Response to Planning Application

From: Arun District Council Greenspace

Application ref: AL/87/21/PL

Location: Oldlands Farm Newlands Road Bognor Regis PO22 9FJ

client
project
Oldlands Farm,
Newlands Road,
Bognor Regis PO22 9FJ
title
Landscape Planting Plan
drawing number
05-991-701
scale
1:500 @ A0
date
1st June 2021
drawn
CJO
checked
RH
revision
-

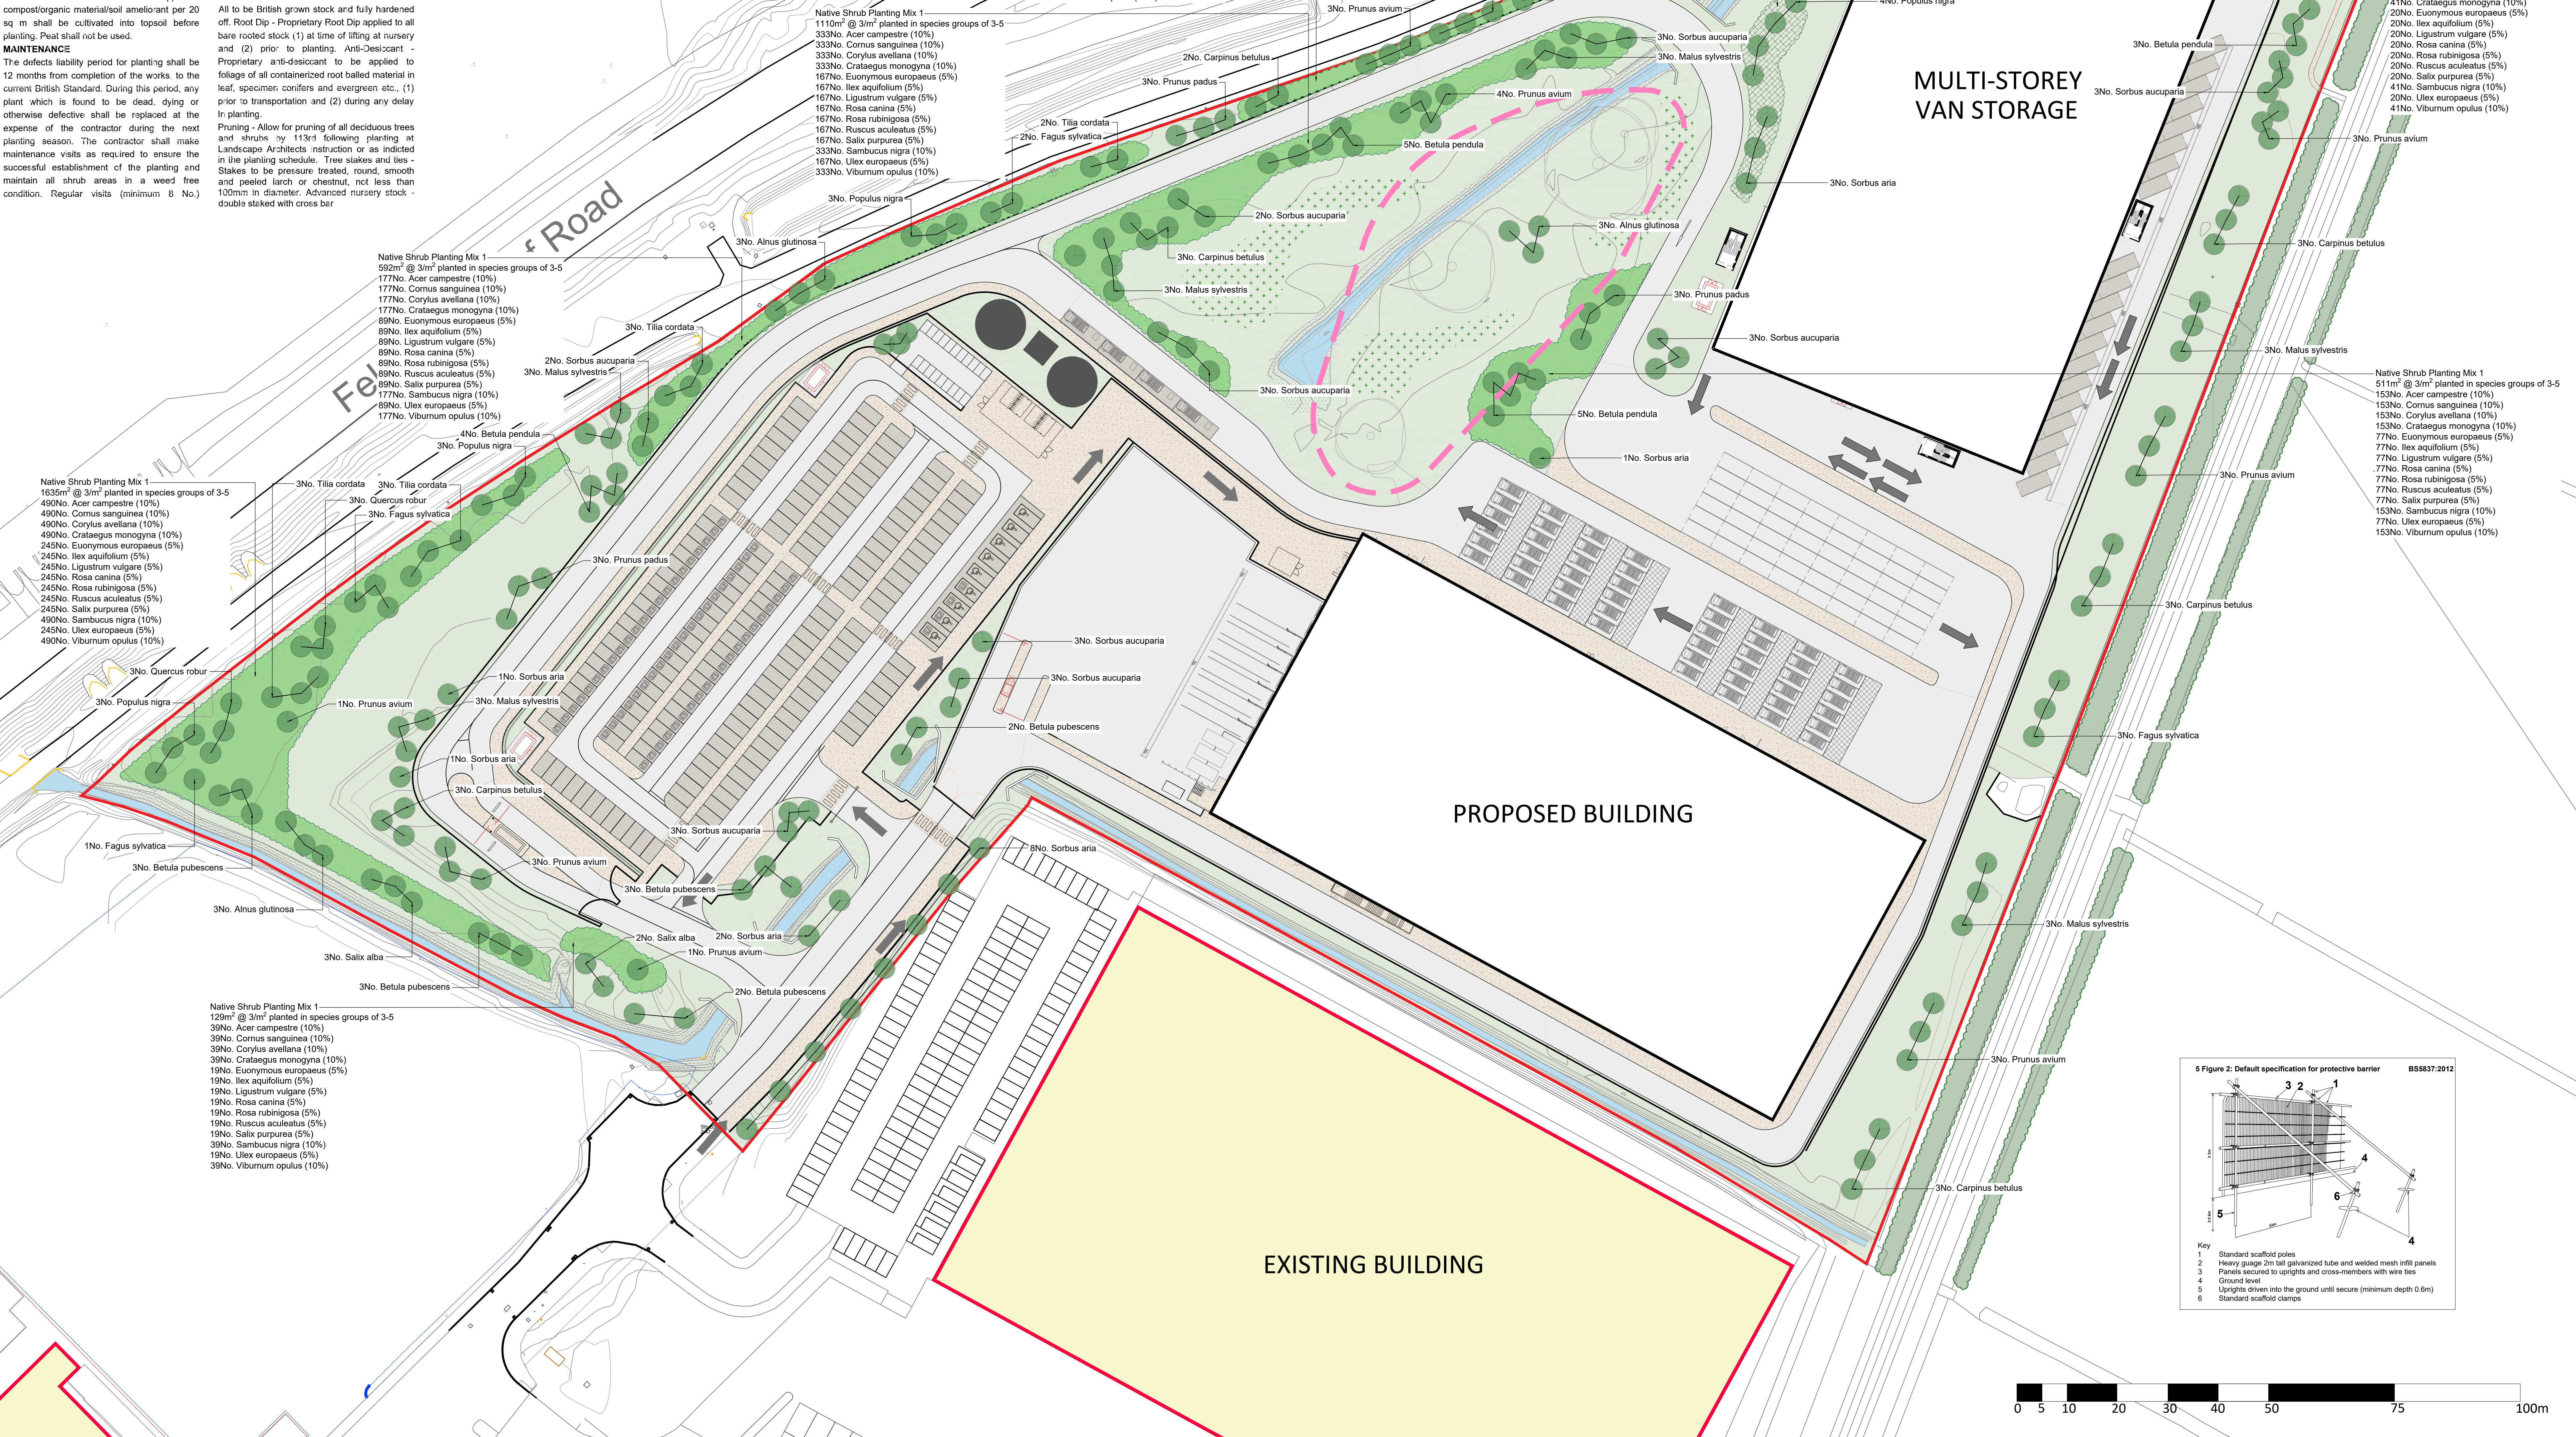
The NPPF para 124/127 relate to good design principles which equally apply to commercial development. The Landscape proposals in Landscape Planting Plan 05-991-701 and Landscape Strategy Plan 05-991-300-Rev A has proposed a scheme with suitable tree and shrub species for location and purpose. The mix indicated has provided good cover with predominantly native trees and shrubs to the periphery and building surrounds. Both the shrub/transplant Native shrub mix 1 and 2 have indicated planting at a good size at time of planting (Native mix 2 at a 1.6-1.8m size at time of planting) which is encouraging to see and will provide instant maturity to the scheme.

I would request that the drawings above be amended for clarity as follows: The tree stock indicated as 18-20cm girth is a nursery stock BS3936 Semi Mature tree classification and not a Select Standard as shown. Please request dwg amend to show these trees (where 1.8-20 girth) as Semi Mature trees and not Select Standards as intended.
